Rezoning Transportation Analysis

Petition Number: 2022-137

Date	Description
01-26-23	First Review (PDM)
02-22-23	Second Review (JP)
03-29-23	Third Review (PDM)

Plotted By: Watts, Austin Sheet: Set Shopton Rezoning - Layout-RZ-1 TECHNICAL DATA SHEET March 20, 2023 06:28:13pm K:\CHL\PRJ\015272_AAC\048 Shopton Road Industrial\02 - DWG\PlanSheets\Rezoning\RZ-1 TECHNICAL DATA SHEET.dwg

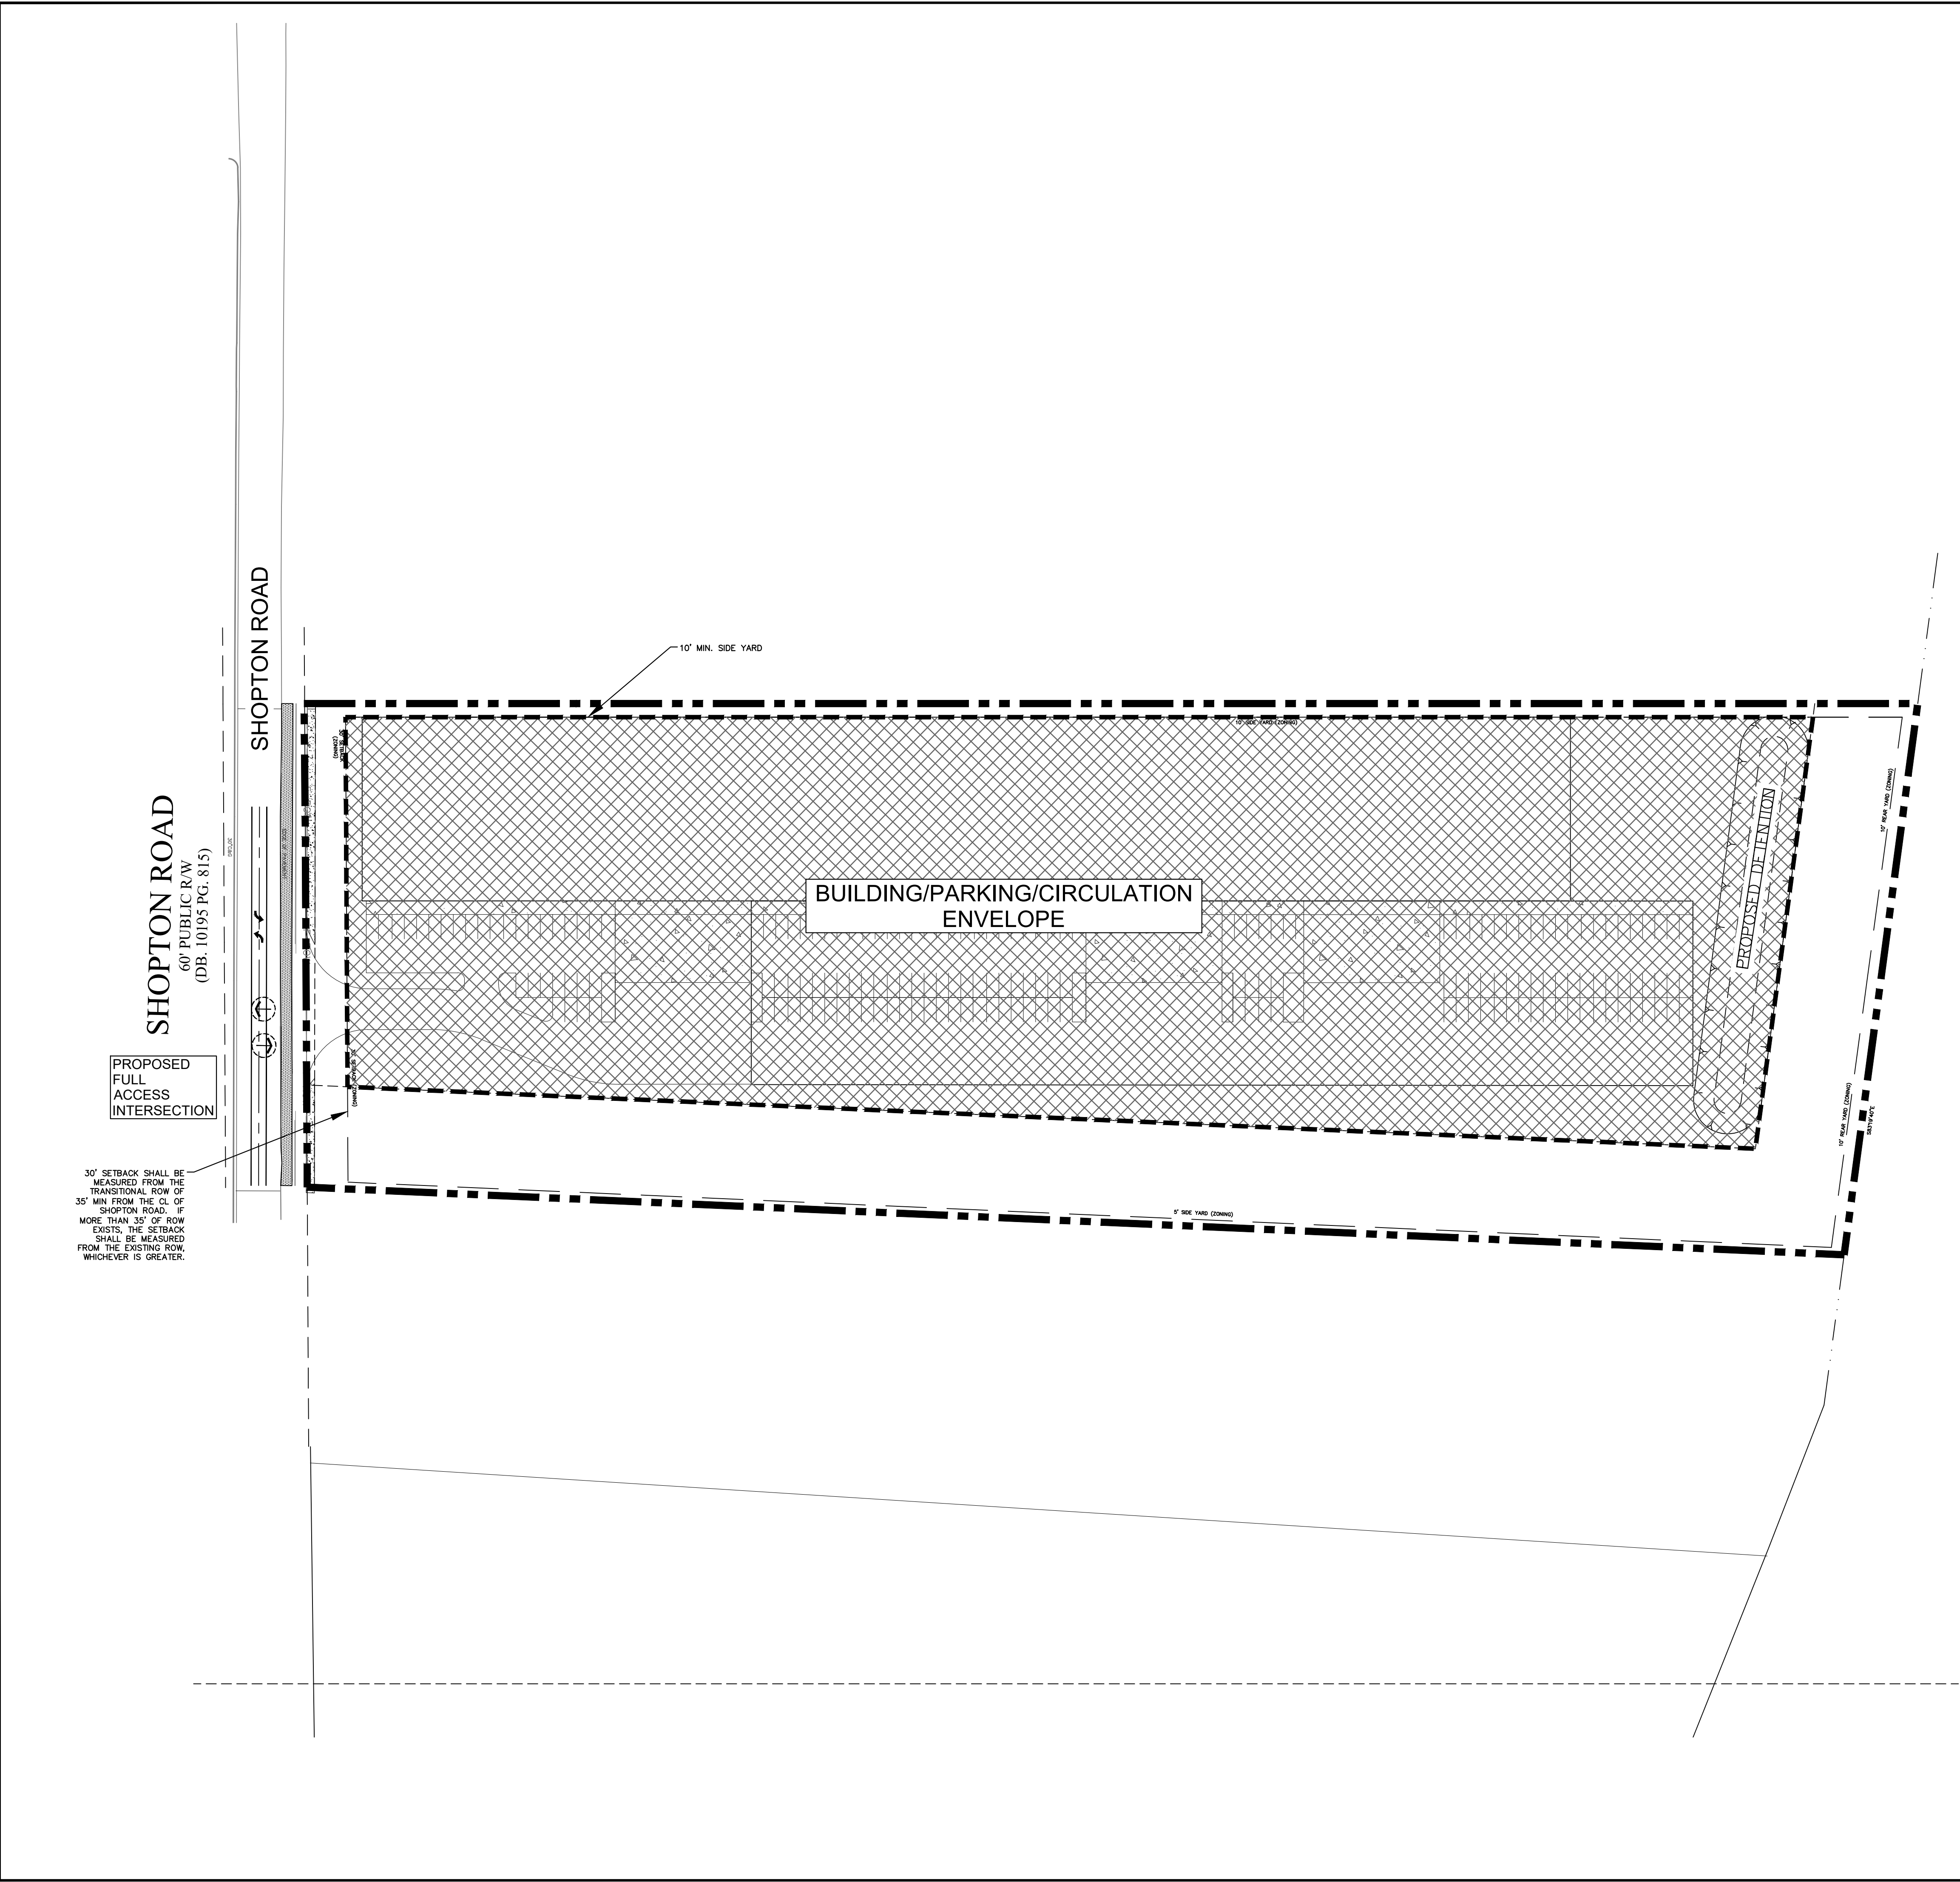
Clarifying Comment from 2-22-23: Site plan is showing 8' and 6', streets map calls for 8' and 8', please revise to provide an 8' sidewalk
6. ~~Site is to remain in the ETJ. Revise site plan and conditional note(s) to construct 8-foot planting strips and 8-foot sidewalks on Shopton Road. The site plan shall label and dimension both items from the back of curb and gutter or edge of pavement. Add conditional note: The entire facility must be outside of the right of way and within a public access easement. Add conditional note committing to construction and maintenance of the 8-foot sidewalk on Shopton Road.~~

Plotted By: Watts, Austin    Sheet: Set Shopton Rezoning - Layout RZ-1    TECHNICAL DATA SHEET    July 14, 2022    06:44:25pm    K:\CHL\_PRL\015272 AAC\048 Shopton Road Industrial\02 - DWG\PlanSheets\Rezoning\RZ-1 TECHNICAL DATA SHEET.dwg

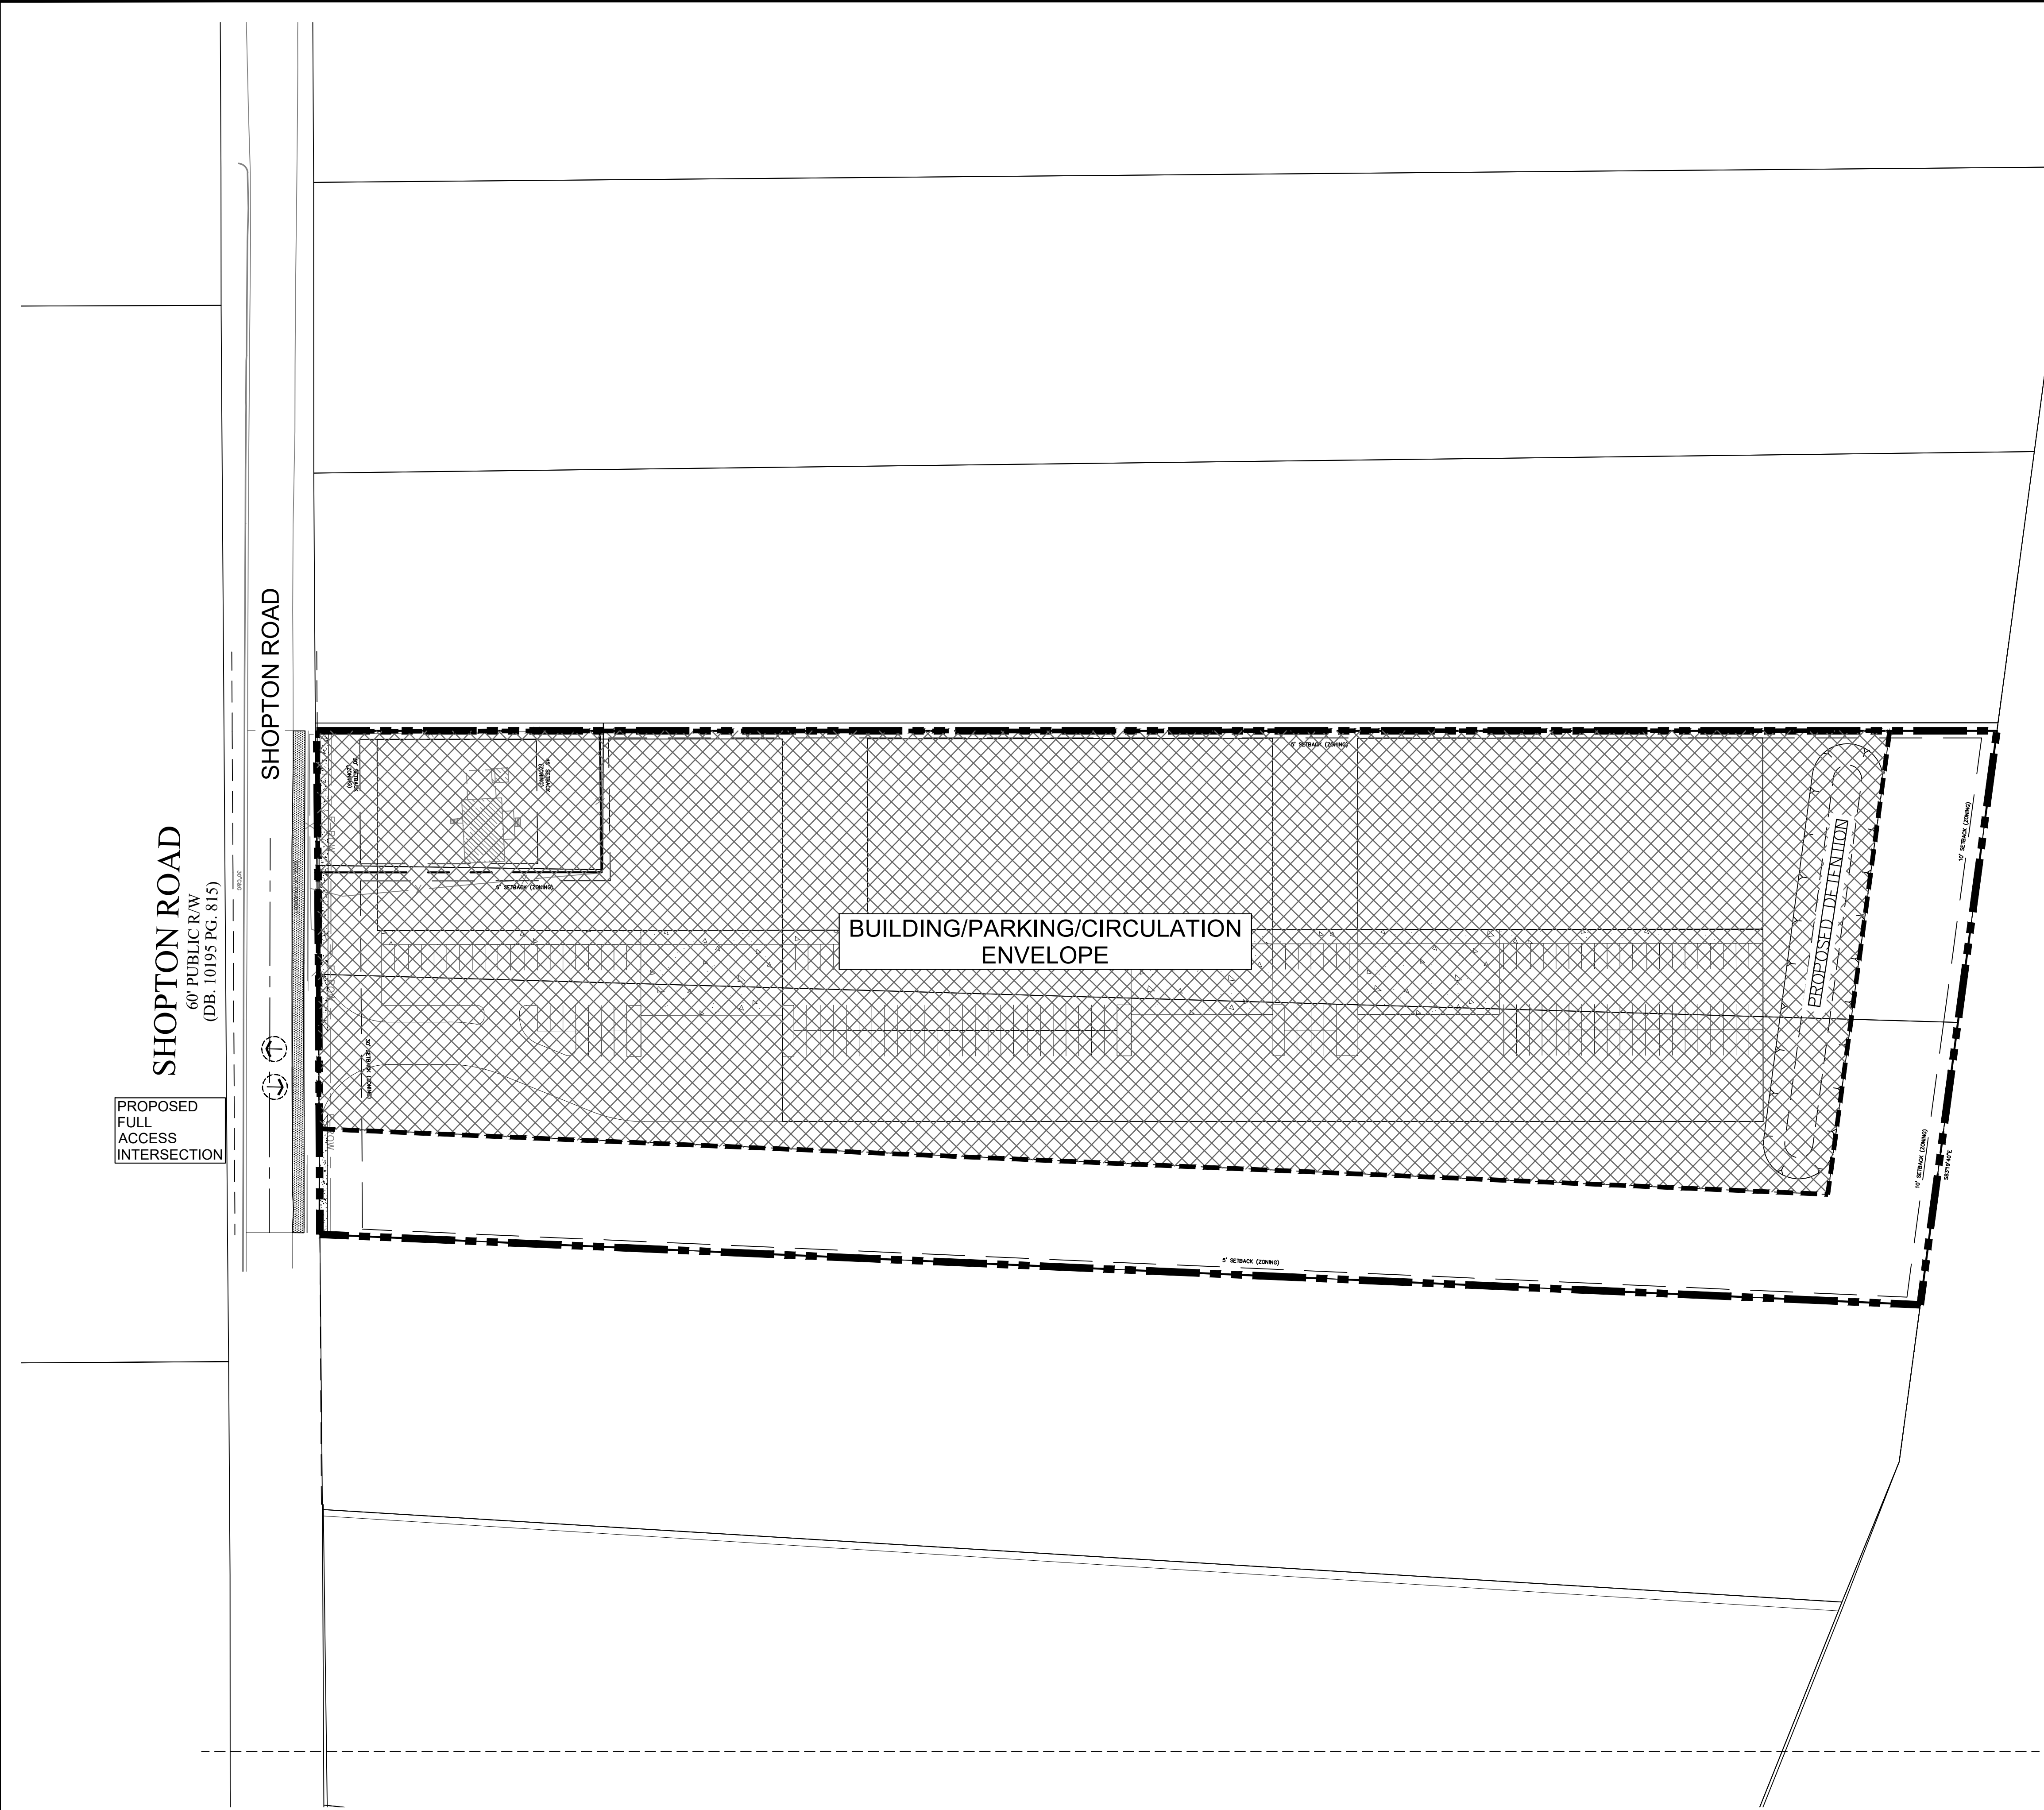
- a. ~~**Shopton Road:** Location of curb and gutter to be moved to 27 feet from roadway centerline to accommodate the Charlotte Streets Map with a roadway typical section of a two plus lane avenue with buffered bike lanes.~~

~~Label and dimension the curb and gutter from the centerline for each road on the site plan.~~

3. ~~Per coordination with NCDOT, restripe the existing median on Shopton Road from Sandy Porter Road to the proposed site access to a two way left turn lane. The site plan should be revised to show the roadway laneage.~~

4. ~~Per coordination with NCDOT provide and dimension a 100-foot minimum protected driveway stem dimensioned from the ROW.~~
5. ~~Revise site plan and conditional note(s) to commit to construct an 8-foot planting strip, and 8-foot sidewalk on Shopton Road per Chapter 19. The site plan shall label and dimension both items from the back of curb and gutter or edge of pavement. The wider sidewalk also meets the Charlotte WALKS Policy.~~

7. ~~Revise site plan and conditional note(s) to commit to construct bicycle facilities by locating the curb and gutter 27' from the center line to meet the Council-adopted Charlotte BIKES Policy.~~
